From: Amanda Scholes on behalf of Planning.Responses
Sent: 31 March 2021 12:18
To: Planning Scanning
Subject: FW: LU/45/21/DOC - Cornfield Close

In relation to the Verification Report (ref.: GE18103/VR/JAN21, dated January 2021) submitted in relation to the above, whilst the majority of the report seems satisfactory, there are some discrepancies which will please need to be clarified before EH can provide a complete response. For ease, these queries are detailed below:

Plot 11

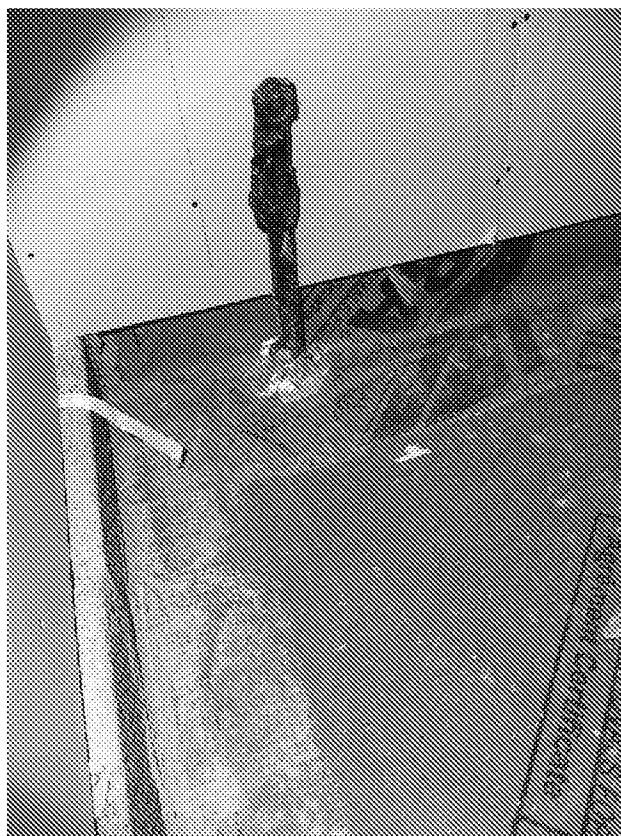
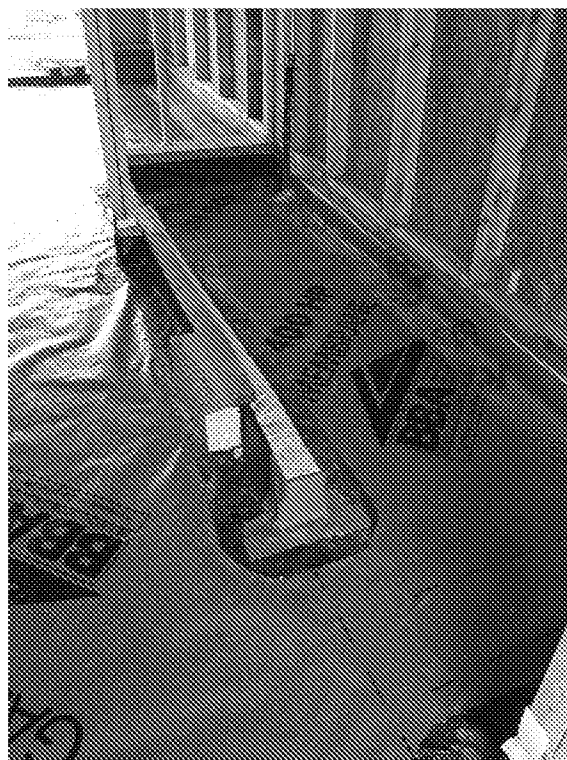
- are the consultants satisfied with the gas protection measures installed? It is understood that Plots 11, 14 and 15 were incomplete at the point of publication, although photographs of the subsequent completion were provided by the applicant's representative.

- are the consultants satisfied with the gas protection measures installed? It is understood that Plots 11, 14 and 15 were incomplete at the point of publication, although photographs of the subsequent completion were provided by the applicant's representative. Geo-Environmental are satisfied with the membranes at the point of inspection and in relation to the additional photographs provided.
- ref to sampling by Bell – I'm not sure what this comment relates to?
